From: Roger Frost [ferring-pc@btconnect.com]
Sent: 04 June 2008 08:50
To: Planning.Responses
Cc: Bryan McCansh
Subject: Re: Planning Consultation on: FG/69/08/ *SC*

ACK**OBJECTION - FG/69/08 - 34 Elm Park**

date. April 2008
scale. 1:50 and 1:100
DRAWING NUMBER 14408.1.

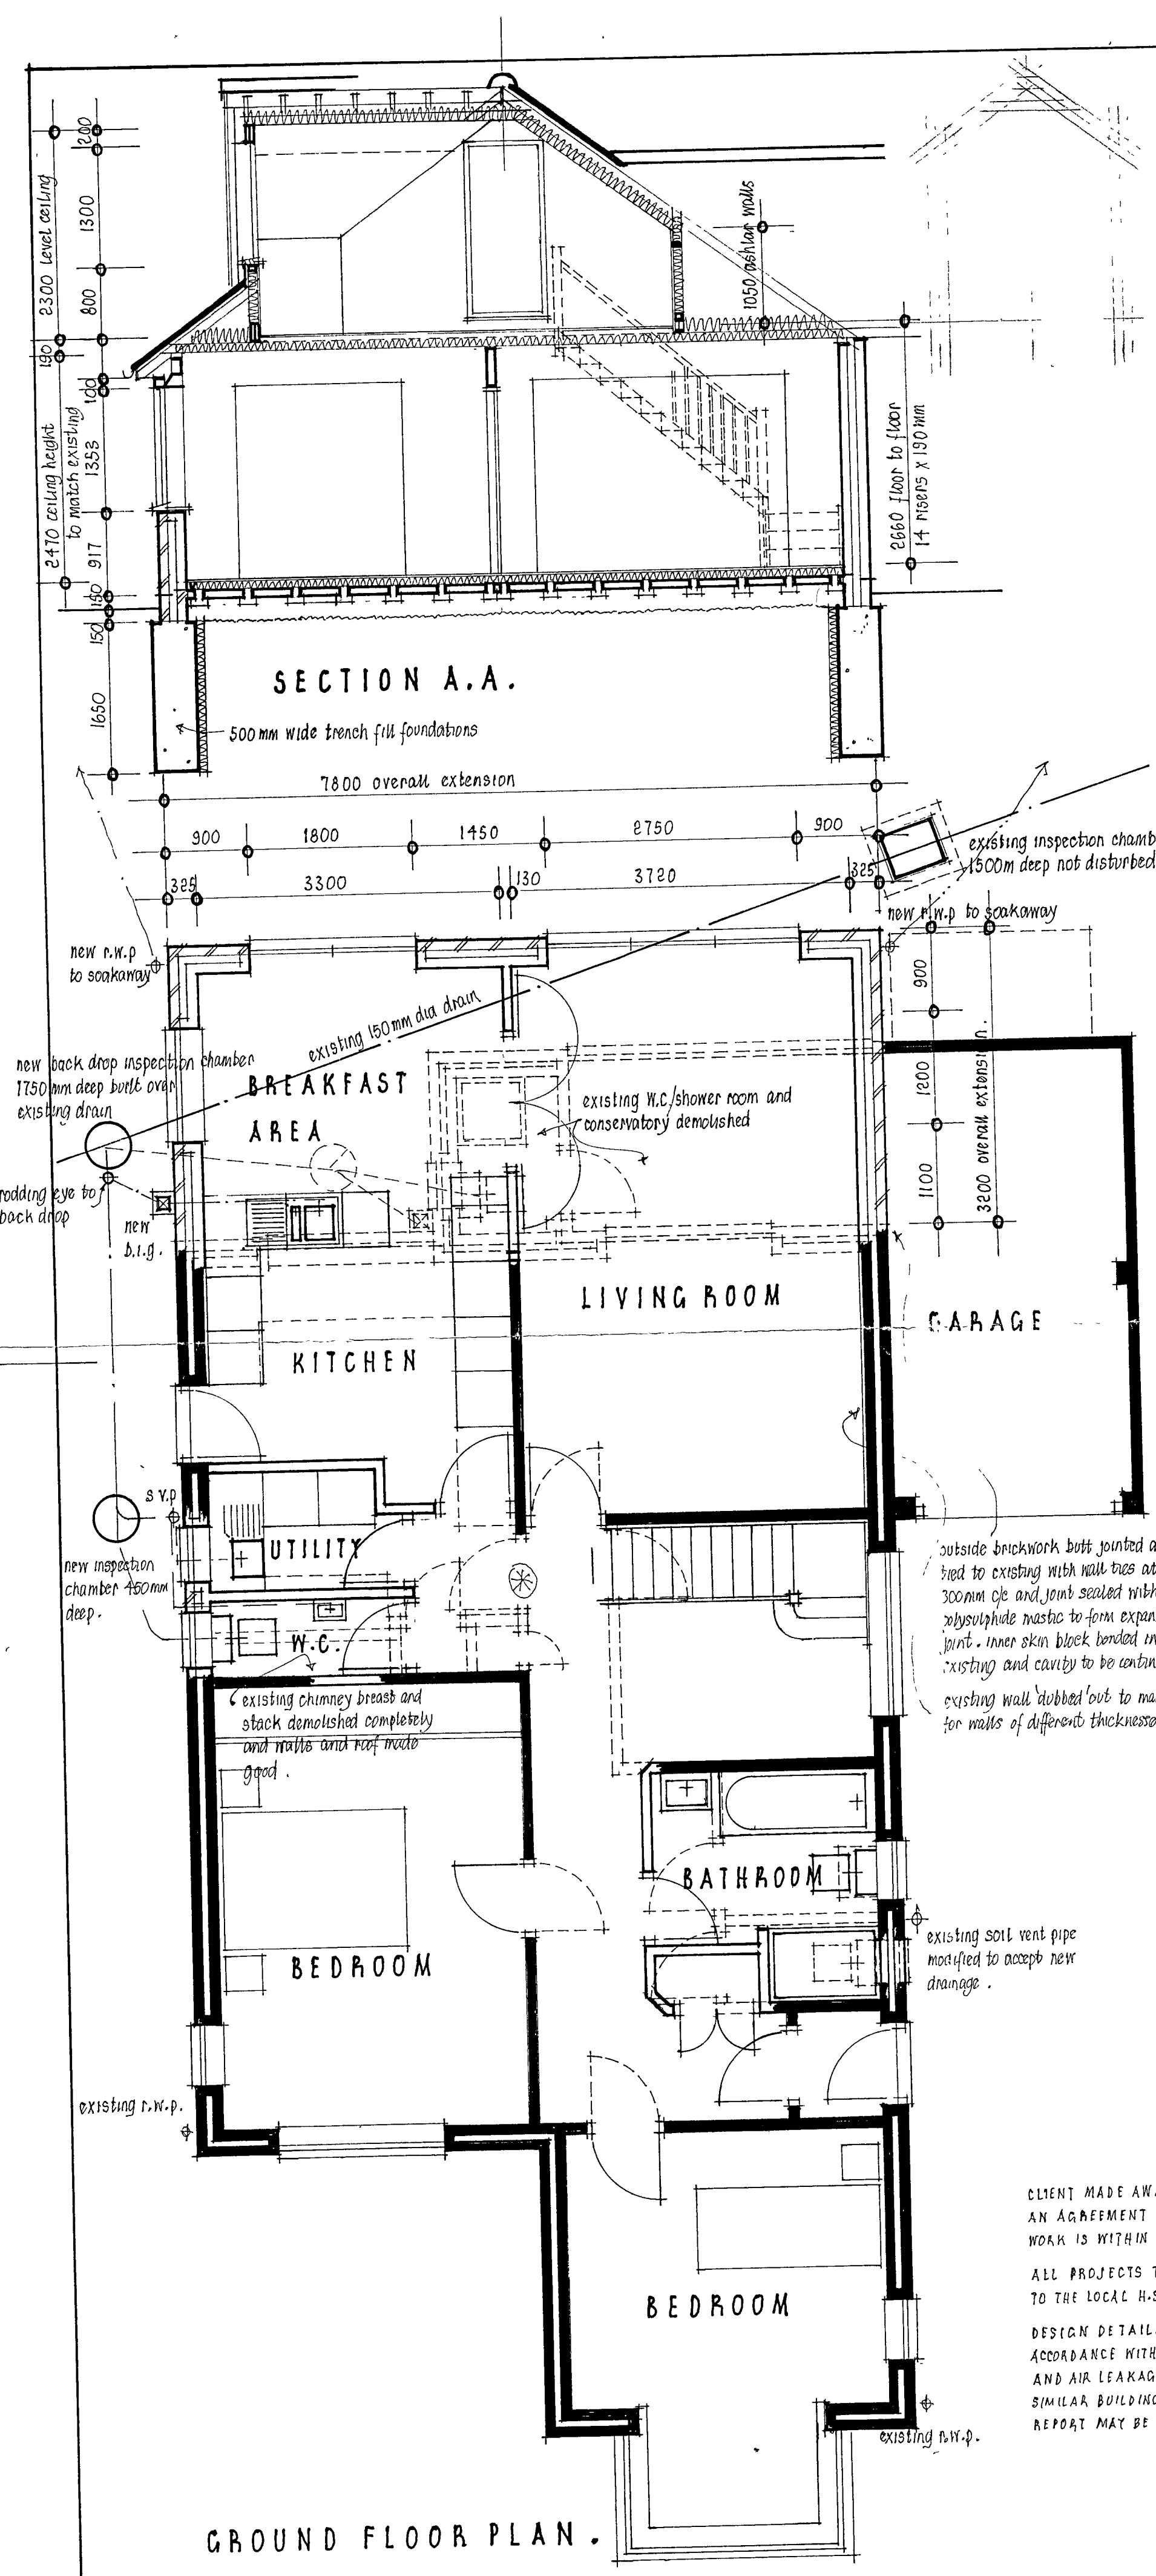
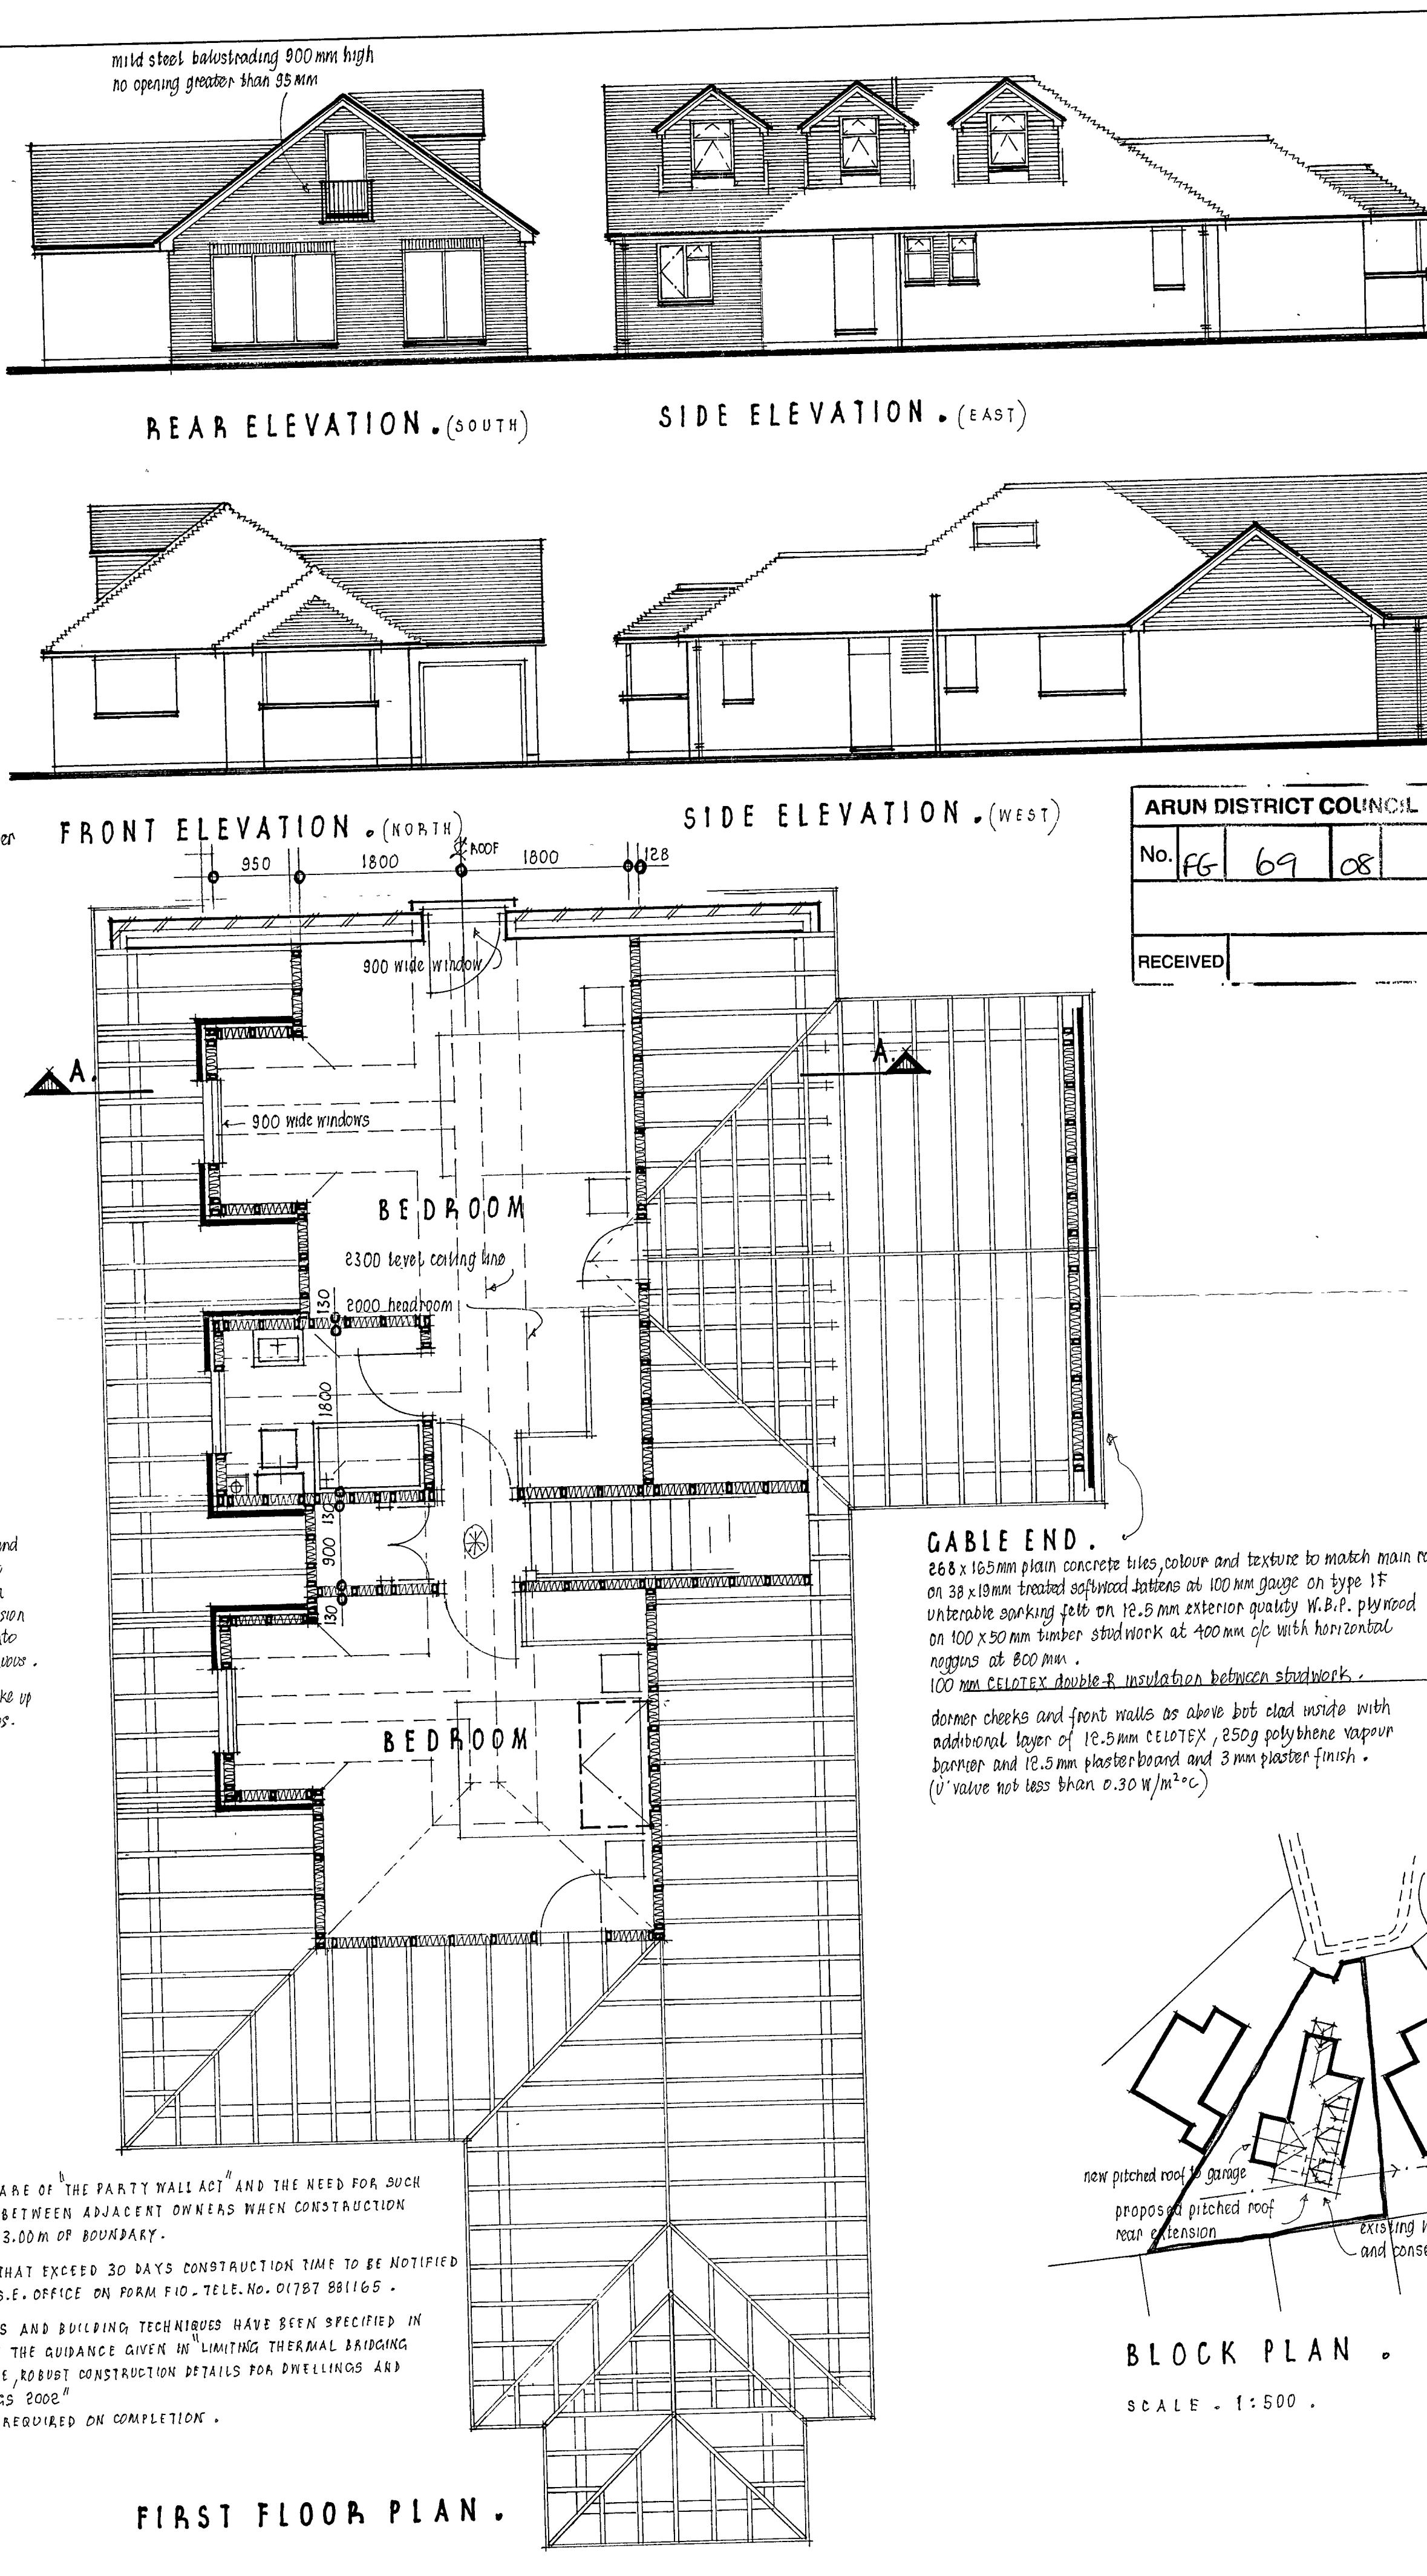
The Parish Council considers this proposal to be an undesirable , un-neighbourly and overbearing development in an area of low rise properties. which does not accord with the provisions of GEN 7 (ii).

The three dormer windows on the side elevation overlook the house and garden of the adjoining property which does not accord with the provisions of GEN 7 (iv).
The Parish Council wishes to raise strong objection to this development.
